Application by Mona Offshore Wind Limited for an Order Granting Development Consent for the Mona Offshore Wind Farm (Case Ref: EN10137)

**Mr & Mrs M T Leach – Nant Ganol, Y Nentydd, Rhyd-y-Foel. LL22 8EF
IP Ref – 20048465**

Deadline 3 – Response to ExQ1

Figure 1.27: Daytime construction noise impact magnitudes: Site preparation

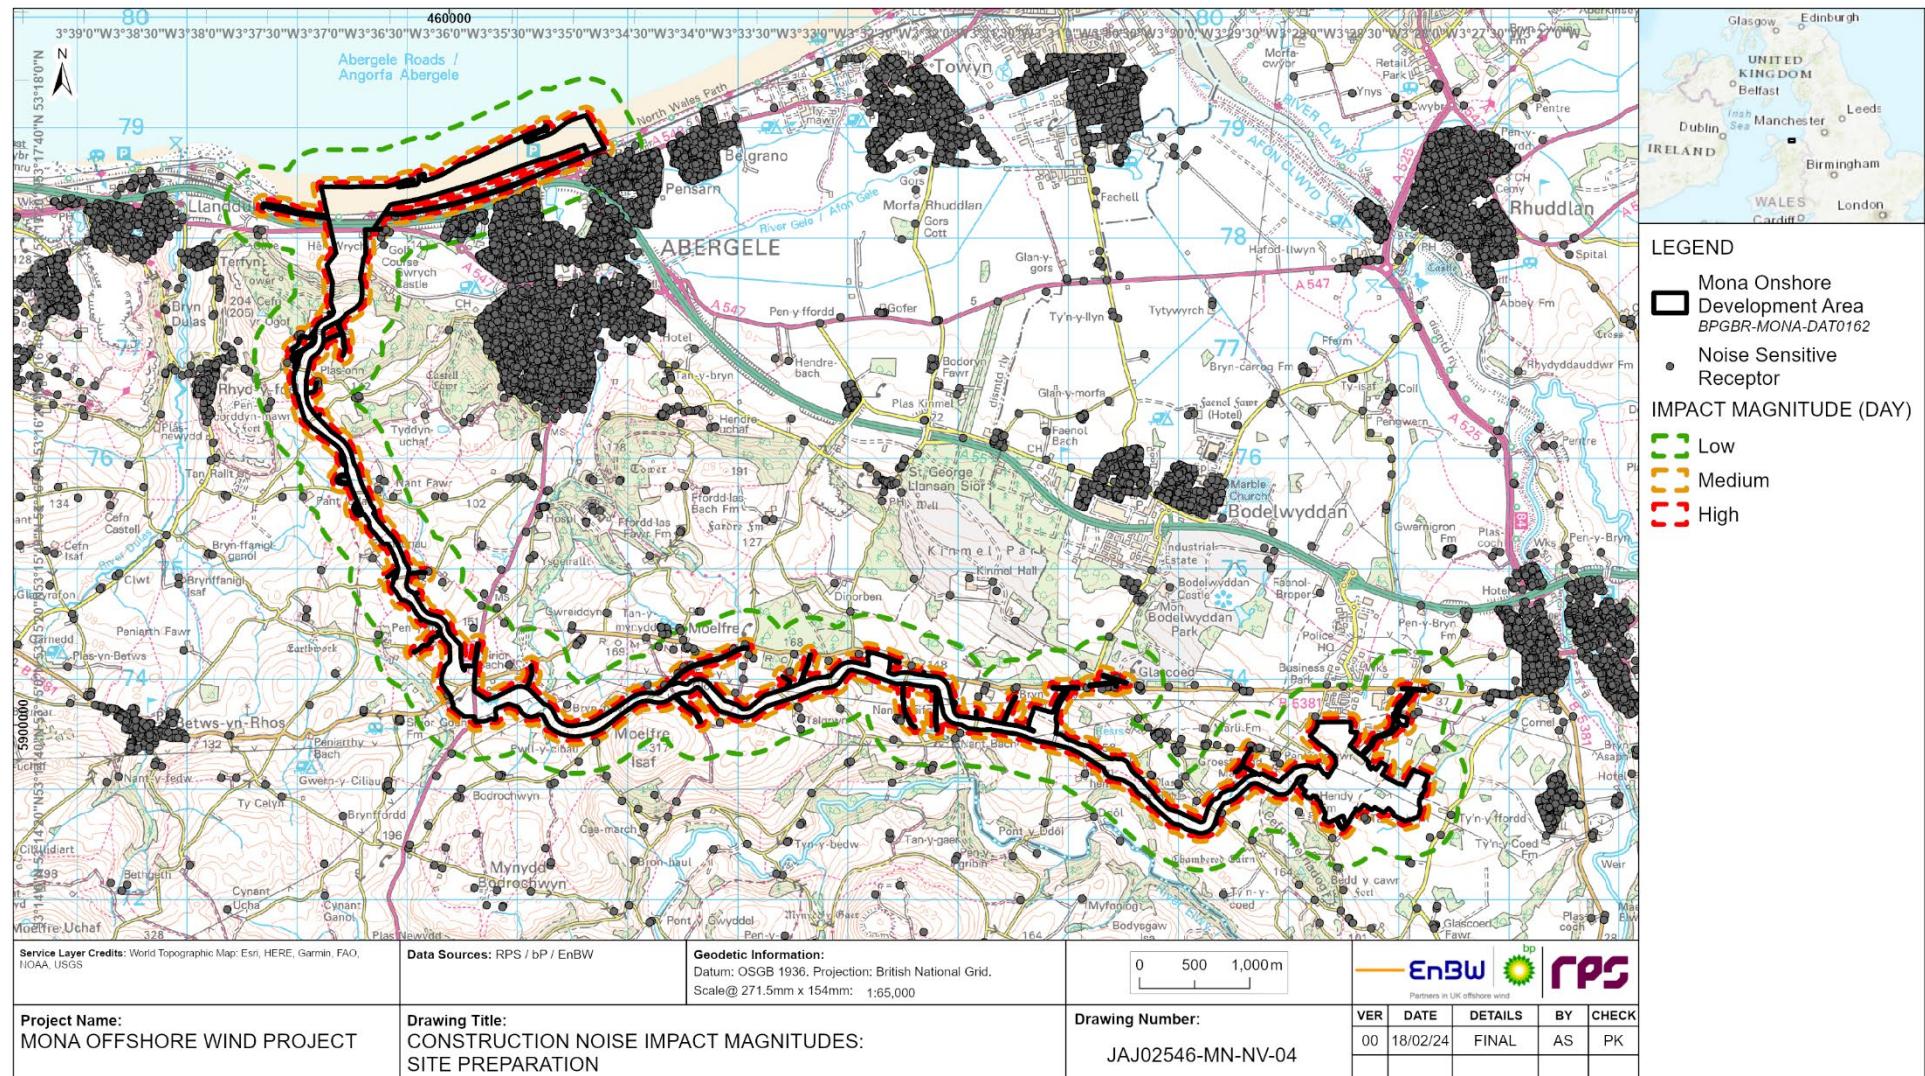
As outlined above, the Outline Construction Noise and Vibration Management Plan does not provide sufficient information on mitigation at Nant Ganol. **Figures 1.27 to 1.34** of the ***Environmental Statement - Volume 7, Annex 9.2: Construction Noise and Vibration Technical Report*** clearly illustrates that there will be a significant impact at Nant Ganol.

It is requested that the project undertakes further engagement with Mr and Mrs Leach to:

- Provide details and assurances of the construction methods, timings and mitigation measures to be implemented proximate to Nant Ganol for the benefit and protection of the property and its inhabitants.
- Provide an assurance that Rule 6 of Section 5 of the Land Compensation Act 1961 and Section 7 of the Compulsory Purchase Act 1965 will apply to the owners of Nant Ganol in respect of any impacts arising from the project.
